Conservation Area Advisory Committee

Meeting Date : 5th June 2017

Ref	Description	Address	Design award
AW/137/17/HH	Single storey extensions for bedsitting room & additional utility room. This application affects the character & appearance of Aldwick Bay Conservation Area.	16 The Fairway Aldwick

EXISTING ELEVATIONS

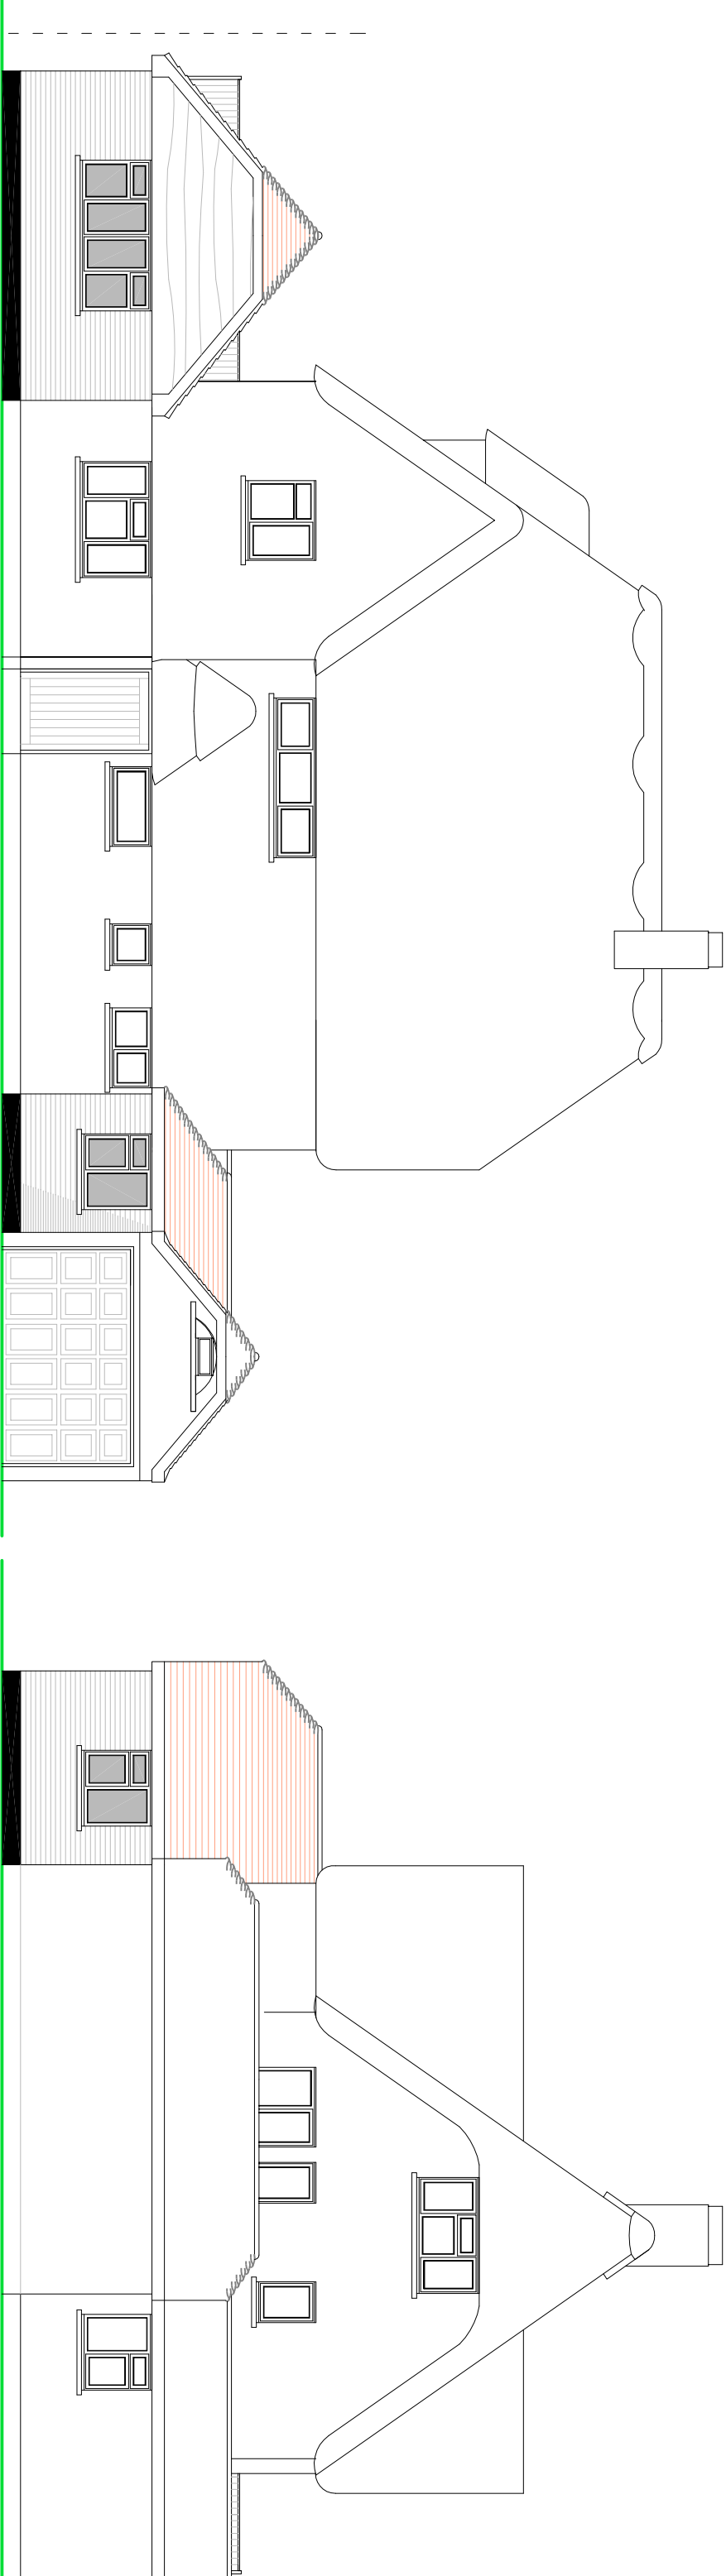
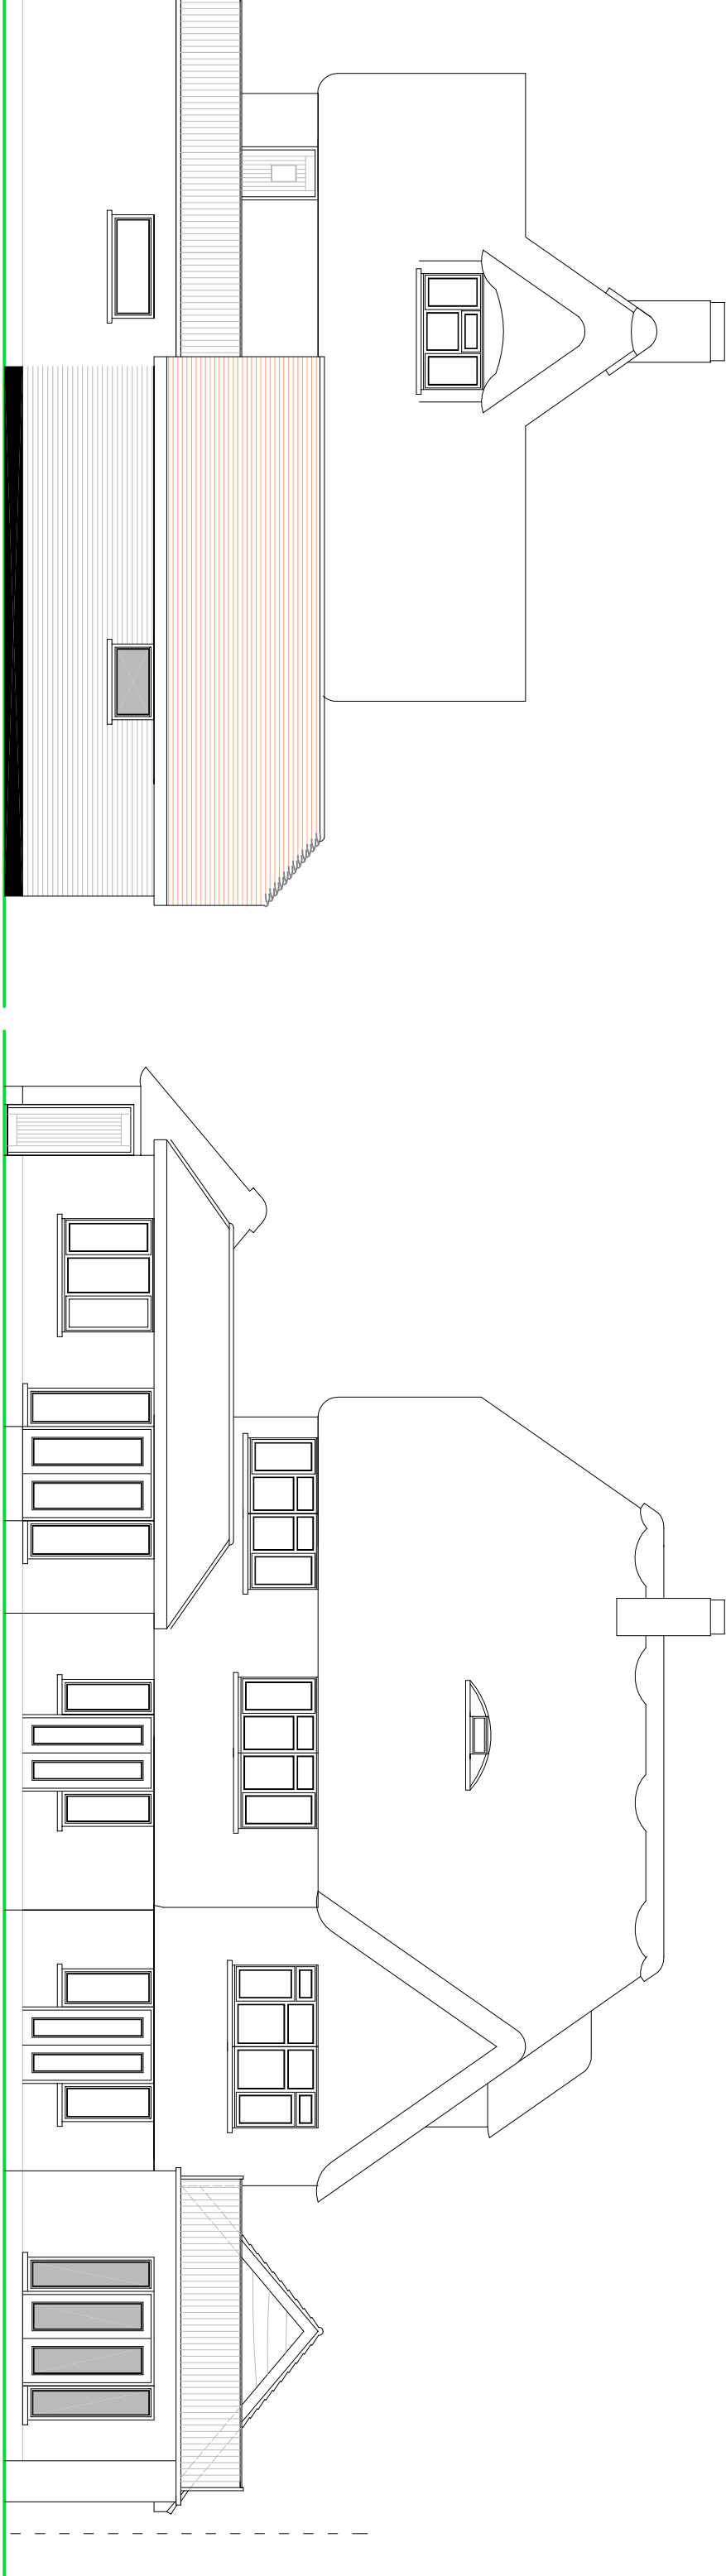
Objection

The extension that projects forward from the main building is of insufficient ~~quality~~ of design and detracts from the main building. We regret the loss of the small archway in the main building. The other extension which is part of the significance of the main building resulting in loss of character to the conservation area.
